**Final Report - Corrections Required**  
**Application No. ANEX-23-0014**

**Description :** A request by Norris Ranch Joint Venture, LLC, for annexation of 19.605 acres into the City of Colorado Springs. The annexation is a part of the overall Karman Line Land Use Plan, which is being submitted concurrently. The Land Use Plan proposes a maximum of 6,500 dwelling units, approximately 45 acres of light industrial, 105 acres of commercial/retail, 100 acres of mixed-use development, and 570 acres of park/open space.

County File: ANX234

Re: Karmen Line Addition

Figure 5  
**Directional Distribution**

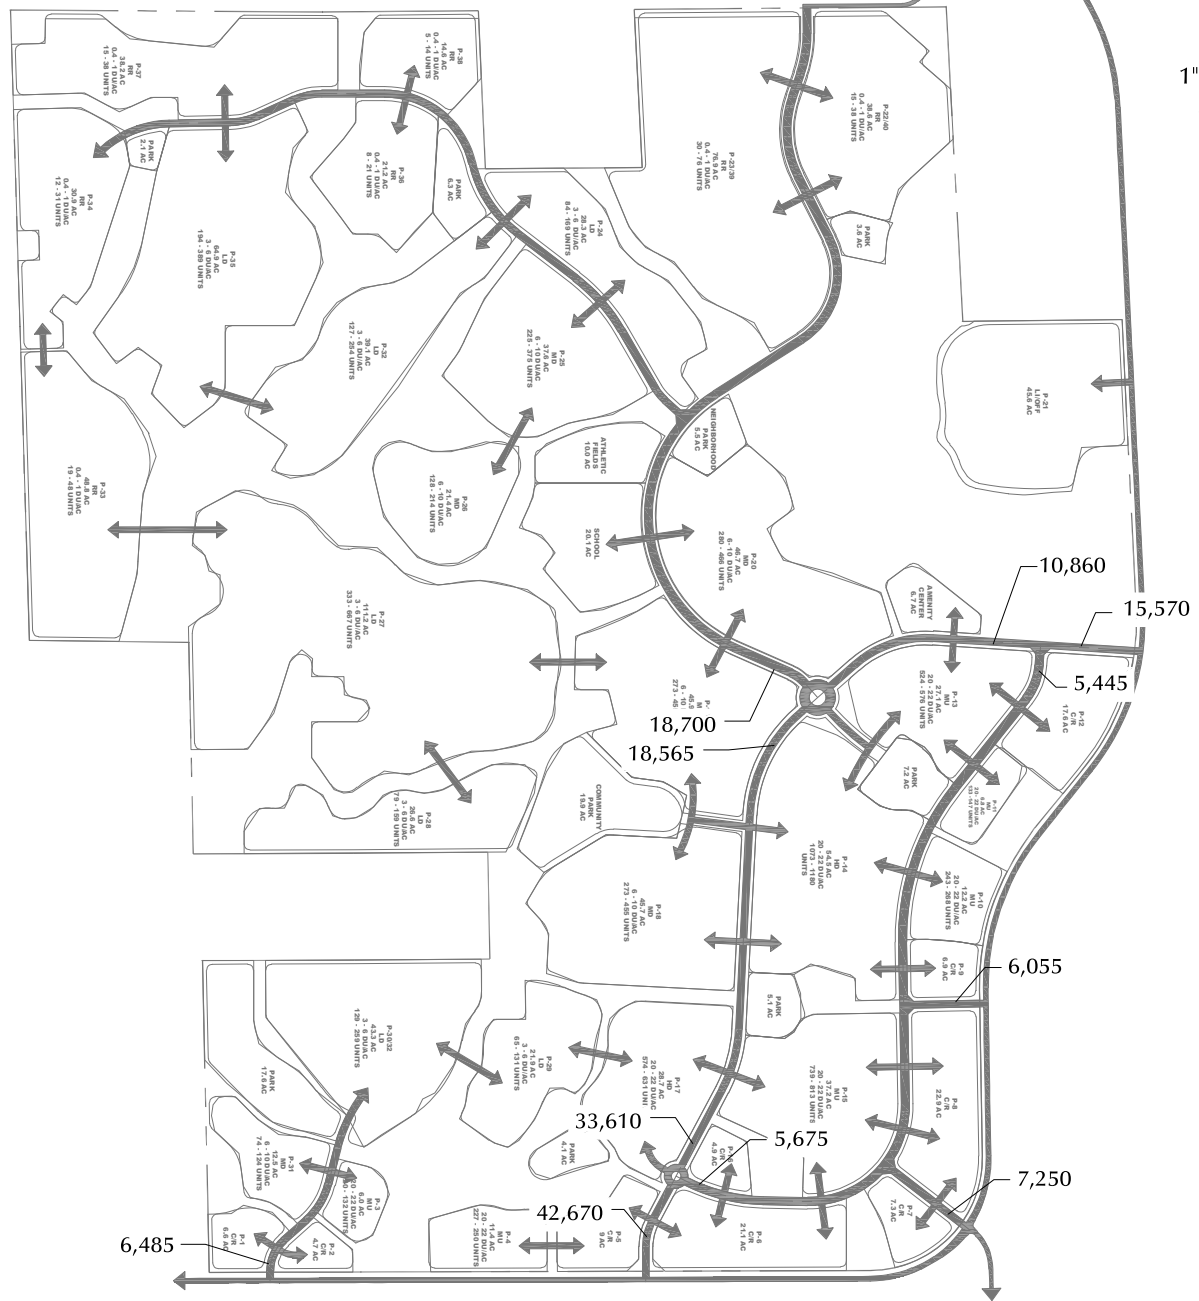
Verify that totals  
← add up to 100%  
(10-17% missing?)

FIGURE 3: MAJOR DRAINAGE BASIN MAP

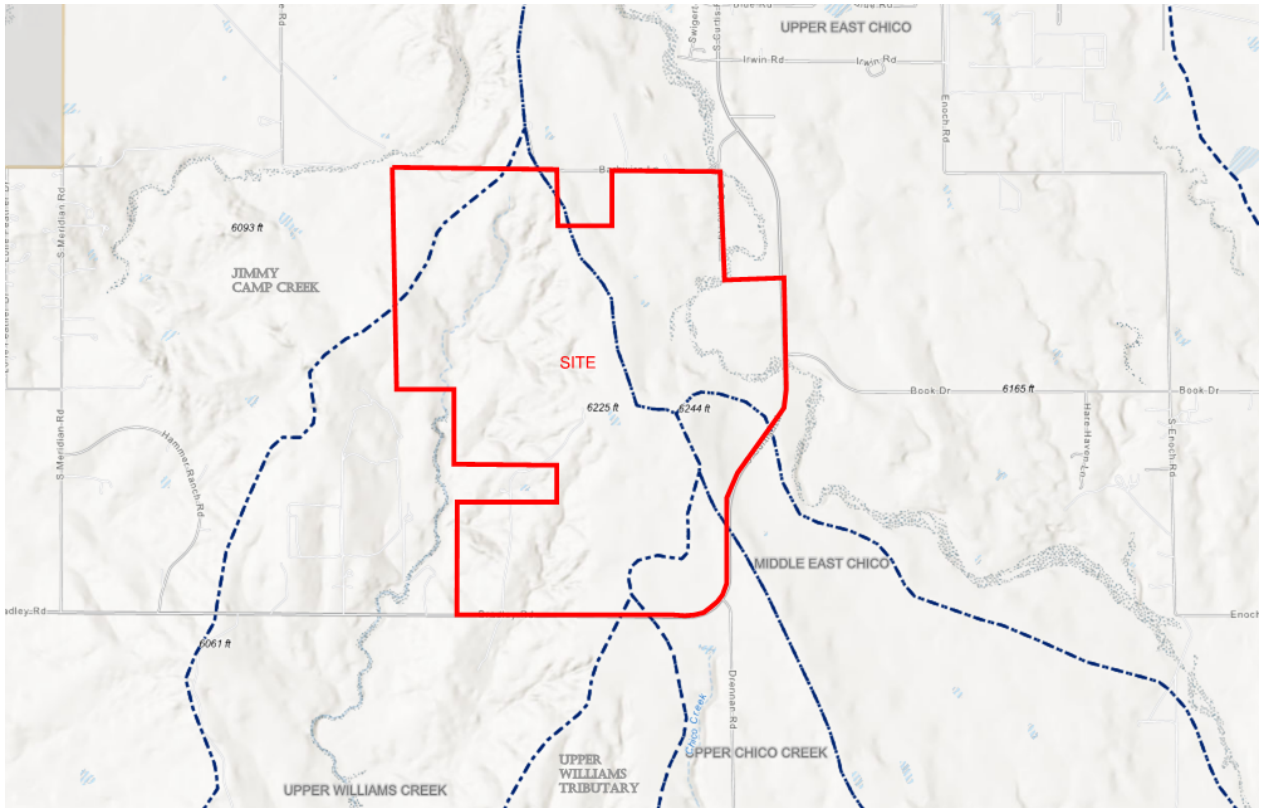
Williams Creek?

Impacts to downstream channels due to increased runoff volumes and durations will need to be addressed in all cases.

County staff wishes to discuss an IGA or other agreement that addresses cross jurisdictional drainage improvements and fees.

Green infrastructure/low impact development should be provided to mitigate impacts to downstream channels.
